Item No. **Report of the Head of Planning, Transportation and Regeneration**

Address 11 WARWICK ROAD WEST DRAYTON

Development: Erection of a two storey extension above the existing commercial ground floor building for residential purposes comprising of 4 x 1-bed 2 person units.

LBH Ref Nos: **9746/APP/2021/2542**

SES-000-1-ESE

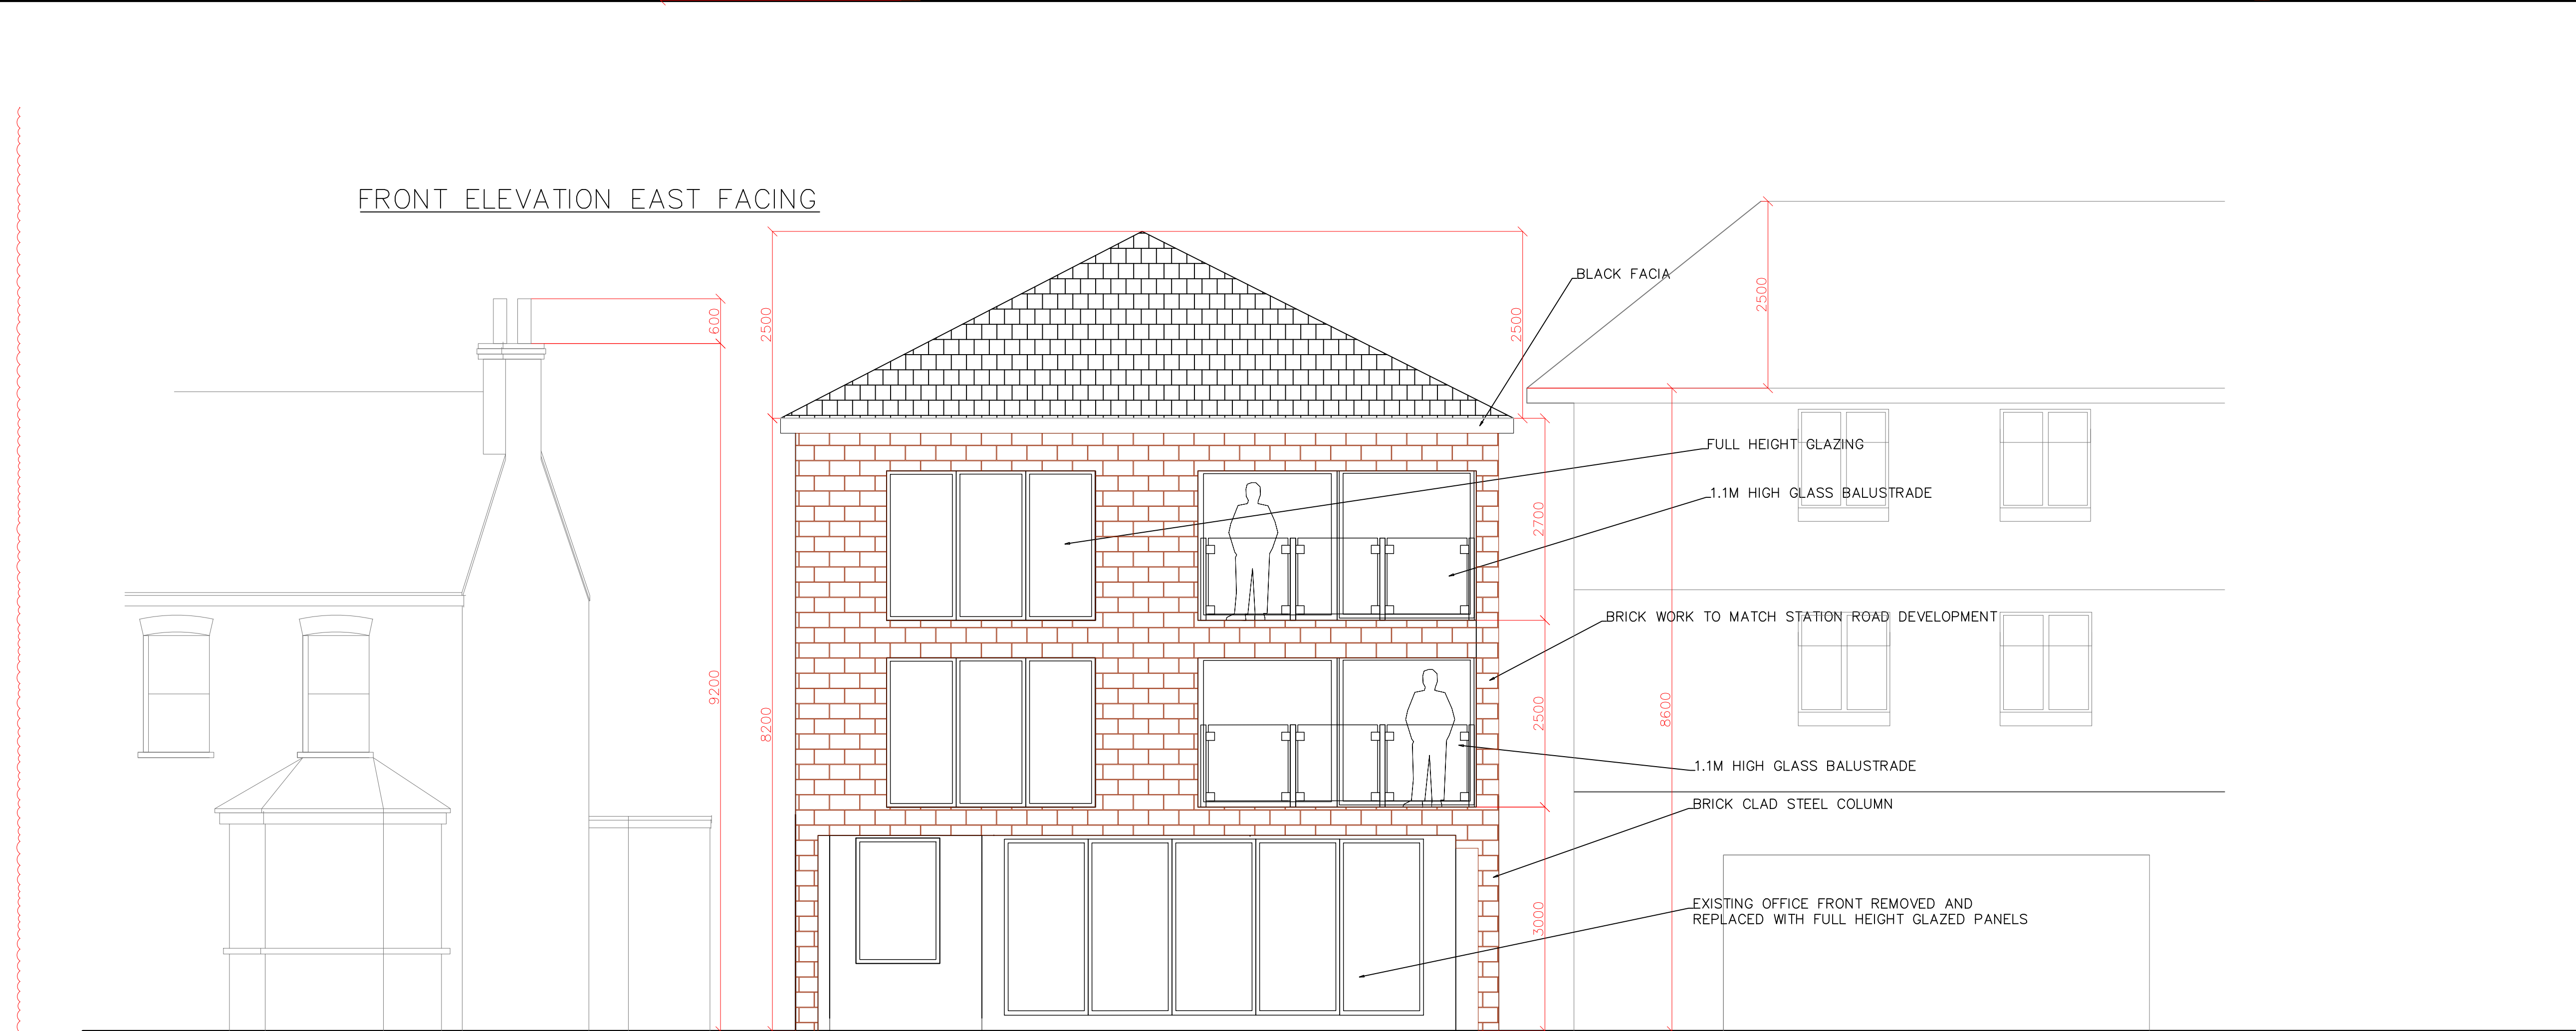
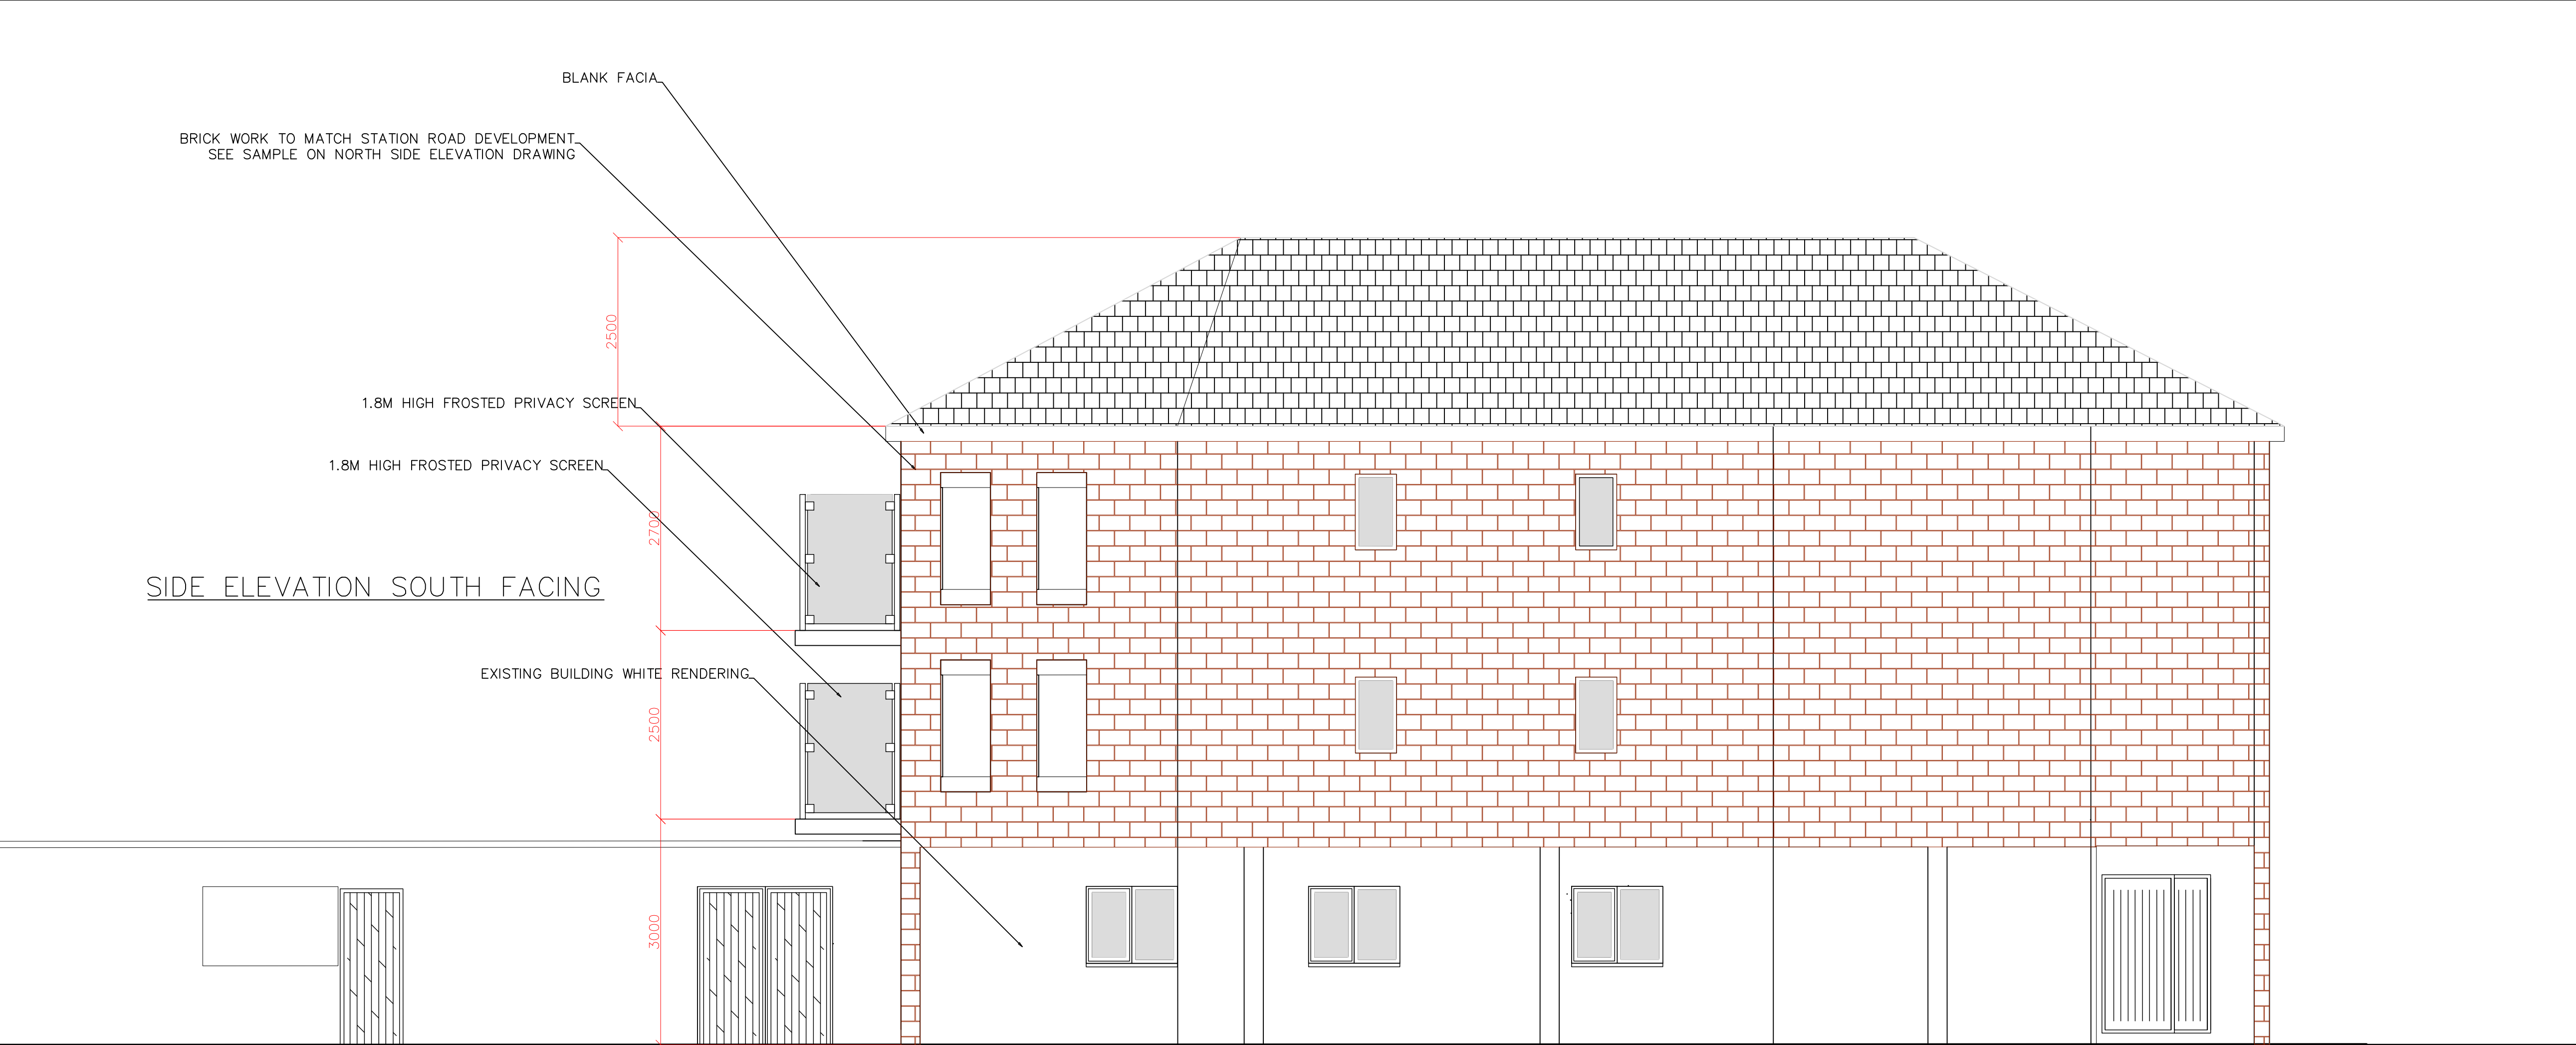
The form and scale of the development would respond to the transitional role the site has, creating a step change between the lower stories of the terraced houses and the larger development to the north. However, the ground floor of the existing offices would be extended with two floors of accommodation which would protrude as far forward as the

bay window at No 9 Warwick Road and therefore would protrude forward of the main wall of this property. Combined with the rectangular form of the development at this point and the blank south elevation, the development would appear awkwardly juxtaposed to No 9 and overly dominant and incongruous within the street scene.

The submitted plans fail to accurately reflect the as built development at adjacent Pullman Court. The approved eaves height of 7.9m and ridge height of 10.4m is not accurately plotted. The proposed building would have an overall ridge height of 12m. and eaves height of 9.3m which would not create the required transitional impact as referred to previously by both the Council and the appeal Inspector.

Concerns remain about the forward projection of the building as raised by the appeal Inspector. This forward projection is considered to add to the visually incongruous form of the development. As such, the proposal would result in a cramped overdevelopment of the site, which would be visually incongruous, discordant and overdominant, therefore failing to harmonise with the established character of the surrounding area. The proposal is therefore contrary to Policy BE1 of the Hillingdon Local Plan: Part One - Strategic Policies (November 2012), Policies DMHB11 and DMHB12 of the Hillingdon Local Plan - Part Two (2020) and policies D4 and D8 of the London plan (2021).
